WEST SUSSEX COUNTY COUNCIL CONSULTATION

TO:	Arun District Council FAO: Maria Tomalova
FROM:	WSCC - Highways Authority
DATE:	4 December 2020
LOCATION:	17 Nyewood Lane Bognor Regis PO21 2QB
SUBJECT:	AW/240/20/PL Change of use of former residential parenting unit (C2 Residential Institution) to 8 bed House in Multiple Occupation (C4 Sui Generis). This site is in CIL Zone 4 (Zero Rated) as other development. More information received.
DATE OF SITE VISIT:	n/a
RECOMMENDATION:	Advice
S106 CONTRIBUTION TOTAL:	n/a

17 NYEWOOD LAN PO21 2QB

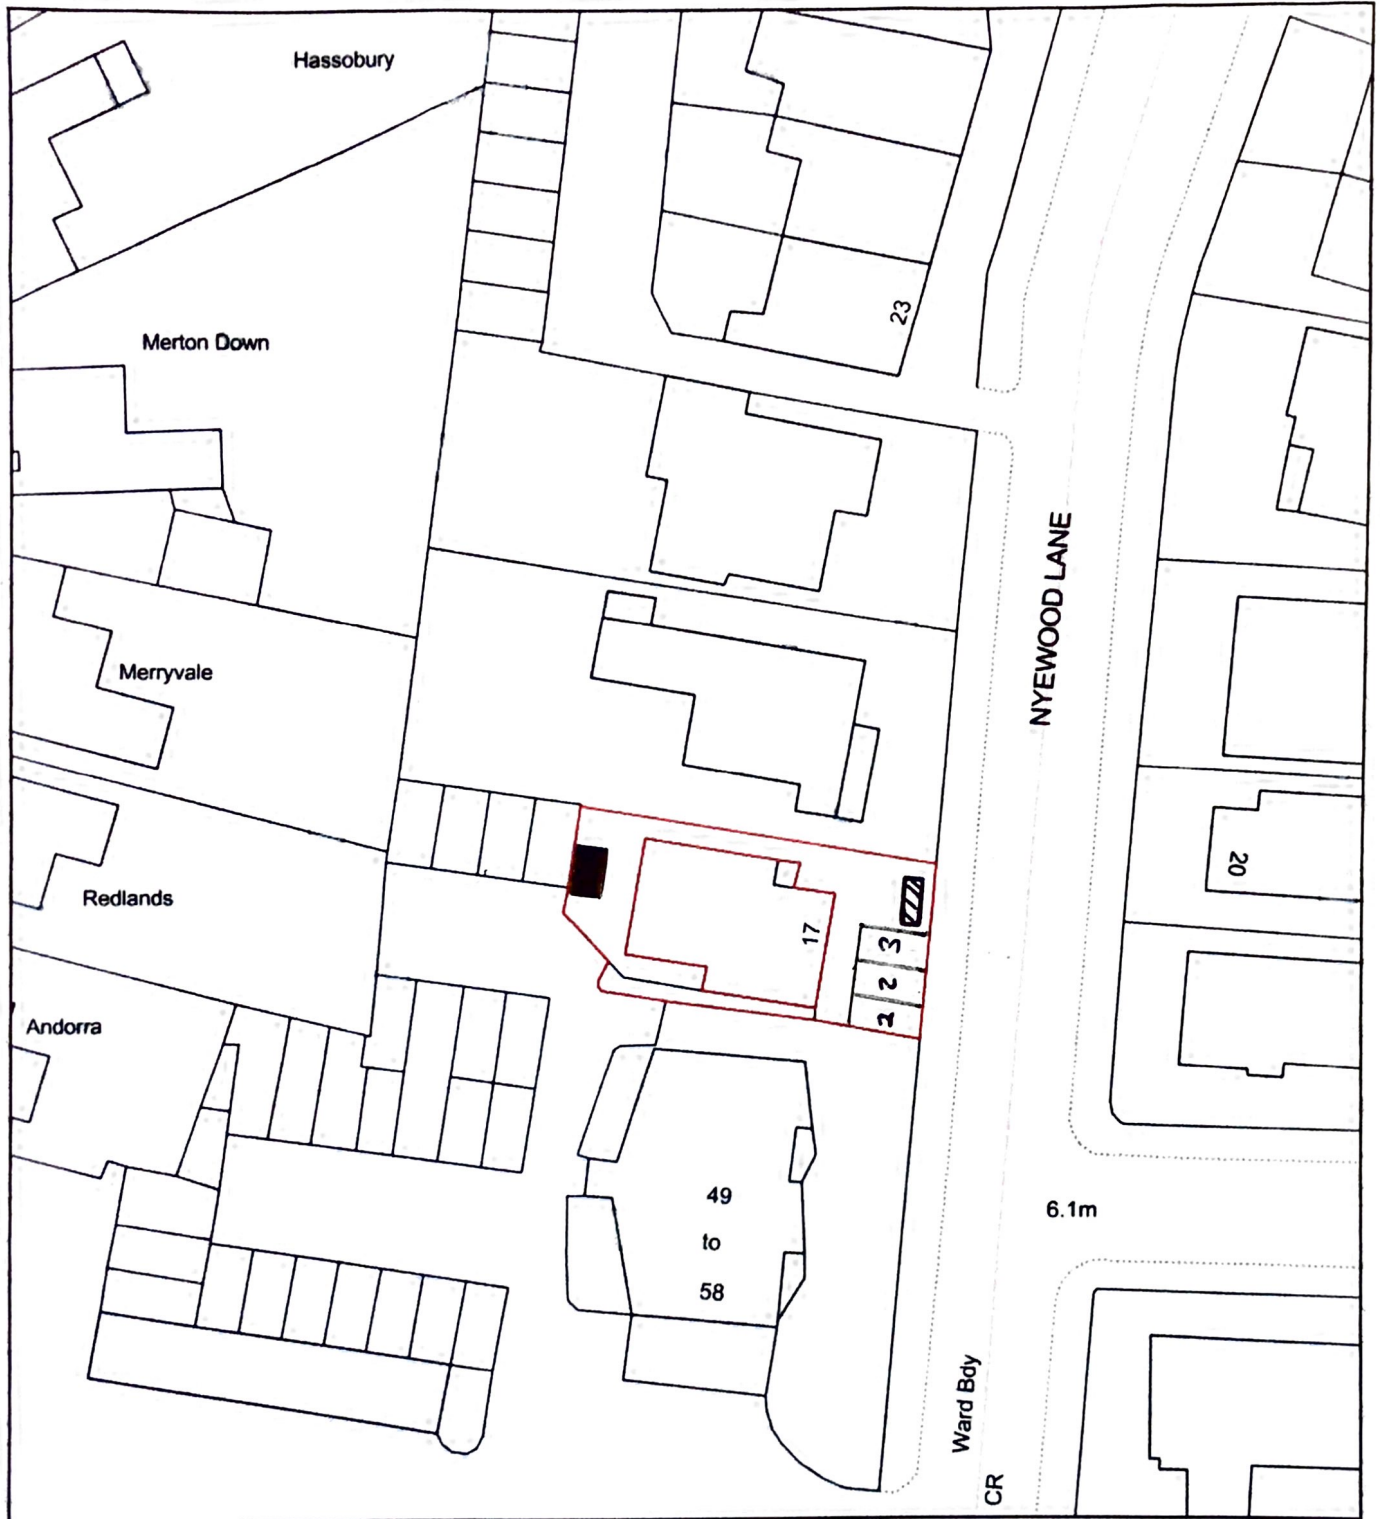
The applicant proposes a 3-parking space provision for the new 8-bedroom dwelling. However, inspection of the plan shows that the proposed hardstanding (6.7 x 7 metres) is only large enough to accommodate 2 parking spaces (2.4 x 6 metres, health and safety obstruction of a doorway or window escape).

WSCC local mapping shows that there are comprehensive parking restrictions prohibiting vehicles from parking in places that would be detriment to highway safety. We would not consider that reduction of 1 car parking provision would detrimentally affect highway safety.

To summarise the LHA raises no concerns over the Vehicle Parking
